154 Island Ave - stair permit

I received your voice mail last week regarding the stair project at 154 Island Ave. Although we have most of the information needed, there is one significant issue you will need to address before I will be able approve the project for zoning.

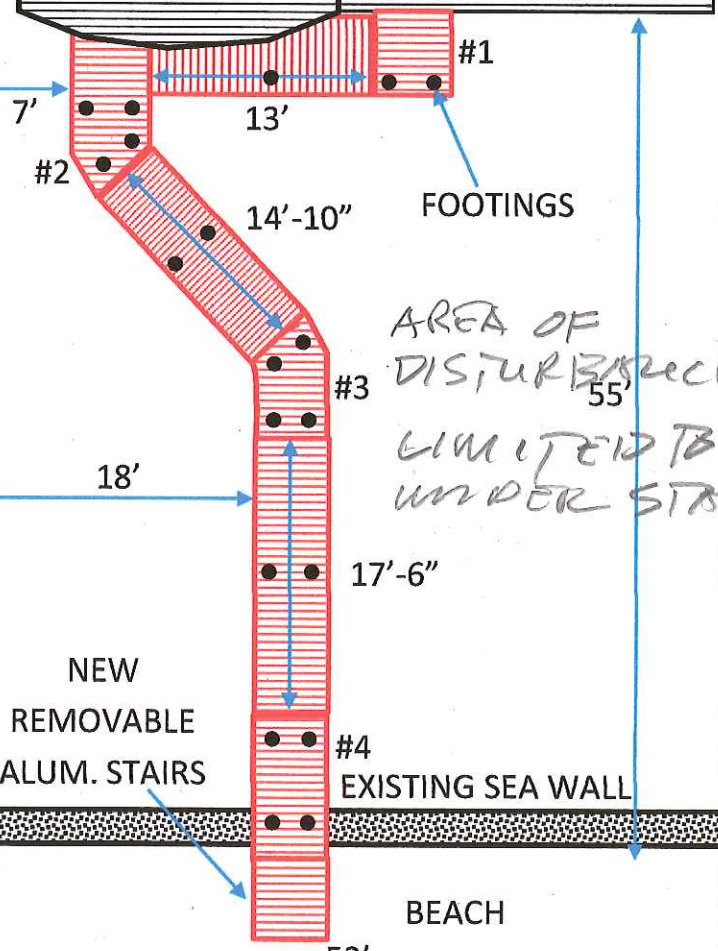
I spoke with Ryan Cianchette about a month ago and he mentioned that a good deal of underbrush has been removed from the property. The Site Alteration application you submitted confirms this, stating that the cutting was done to remove invasive bittersweet. Although this cutting would likely have been acceptable to the city, the project occurred within the Shoreland Zone, so you should have sought approval from the city before undertaking the work. The Shoreland Zone ordinance requires restoration of the buffer by planting replacement shrubs/trees, even though it was apparently largely invasives that were removed.

To move forward, I am requesting the following information:

- Information on the amount/land area of cleared invasive species, and information on any other shrubs or trees (< 2" diameter) that have been or will need be removed - number, species, etc.

- Photos that show the area as it exists now
- A restoration plan detailing the species, number, and location of trees and shrubs to be planted.

We plan to plant 6 to 8 additional shrubs of the types referenced previously, native species such as York Elderberry, Bush-honeysuckle, Highbush Blueberry, and Sweetfern. I hope this information is responsive to your query and that you can now approve the planting plan so that Barbara can move ahead on the Level 2 Site Alteration approval. Please let us know if there is any problem with moving ahead.

No shrubs and, in fact, no bittersweet roots were removed from the site. We did remove a fair amount of trash - old furniture thrown down the slope, pieces of concrete, old bricks, etc. that had been thrown down because the veil of bittersweet could hide these items from view. The concrete landings, some pipe stair structure and pipe handrails of the old stair remain. Many of the existing shrubs and ground cover, consisting of Barberry, Wild Rose and ferns are located near the exterior of the site because that is where there was light. A large dead birch tree was removed and to remove the bittersweet from the tree tops, several branches of existing trees had to be trimmed, but the trees were not significantly damaged. There are areas of the site that were opened up by removing the overhead vines. We talked about this with Jeff Tarling who sent us a listing of recommended species and told us that there were no restrictions on planting them at any time. Prior to the stair being built we are planting in areas outside the area of disturbance of the stair construction. We have begun by planting 15 Blue Rug Juniper and Willowleaf Cotoneaster @ approximately 6' c/c on the north side of the hill. We have purchased an

additional 22 ground cover plants that have a spread of 8-10' consisting of Bar Harbor Juniper and additional Blue Rug Juniper. These will be planted in connection with the finishing of the stair.
